**Subject:** BE/128/17/HH 61 Newtown Avenue, Bersted

1st floor plan

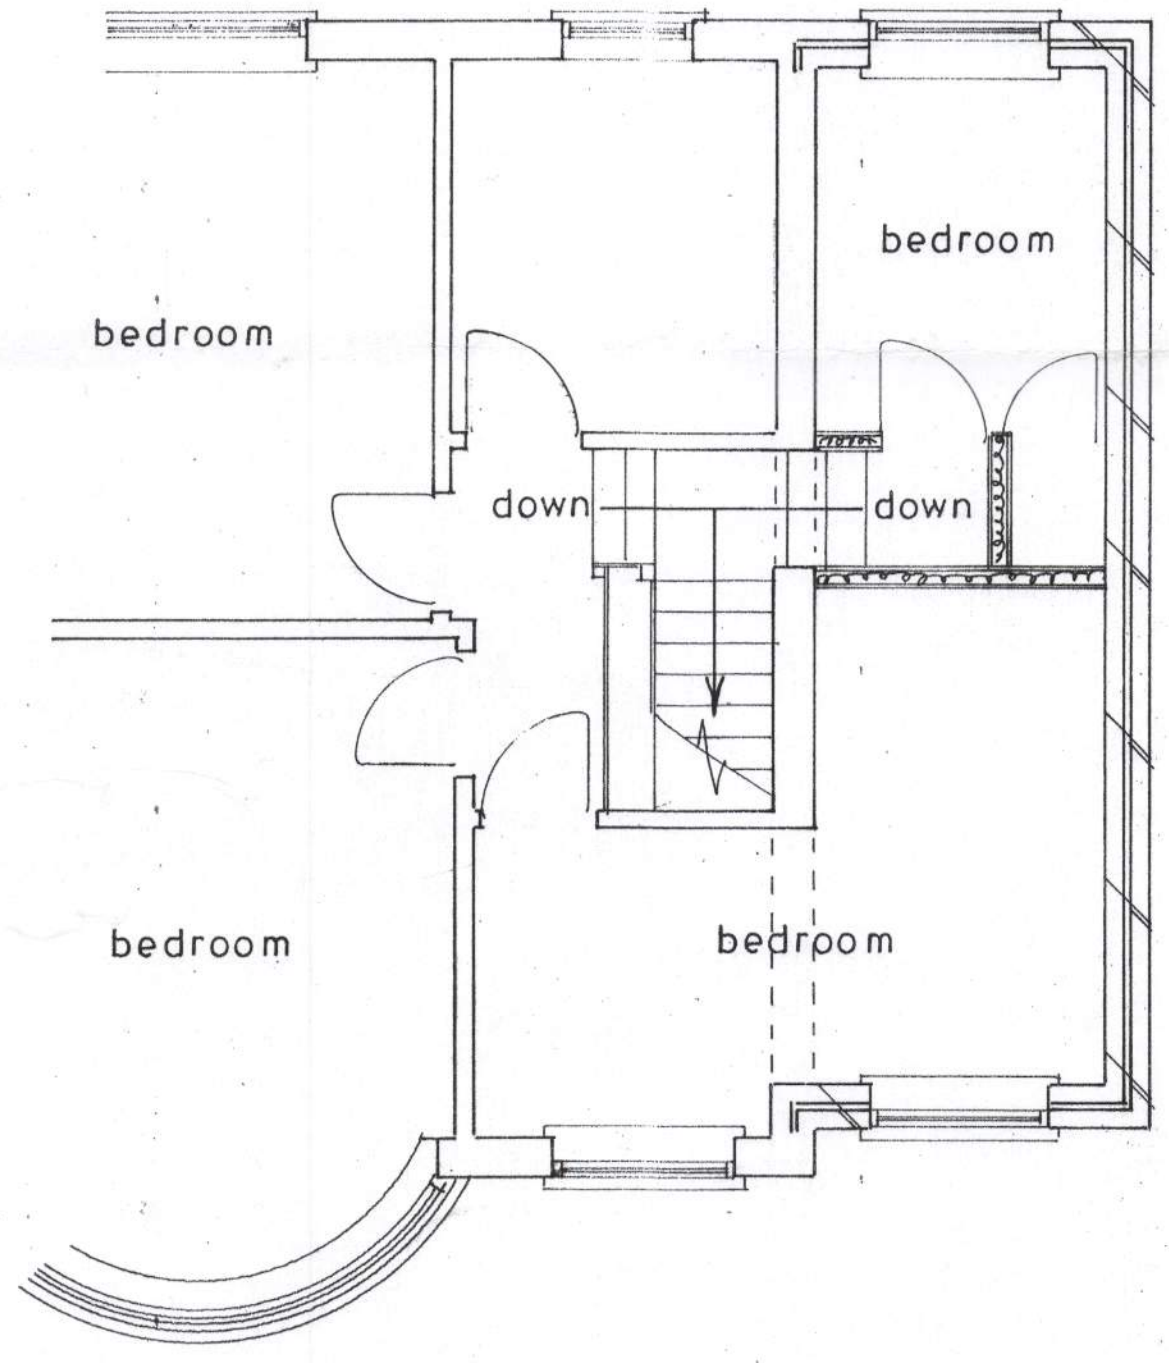
Having spoken to my team leader, would you be able to increase the set off from the common boundary with 59, at first floor level? Ideally to 1m off.

Taking note of the dismissed at appeal at 13 Newtown Avenue in 2015 (BE/120/68/14/HH) we have to have more regard to sections (iv) & (v) of DEV19 below:-

Note that no set off at ground floor is required, so the extension could be built right up to the boundary at that level.

I am awaiting my client's response, but I would suspect that there is nothing to be gained at 1st floor level by stepping it in a metre given the limited distance to the boundary.
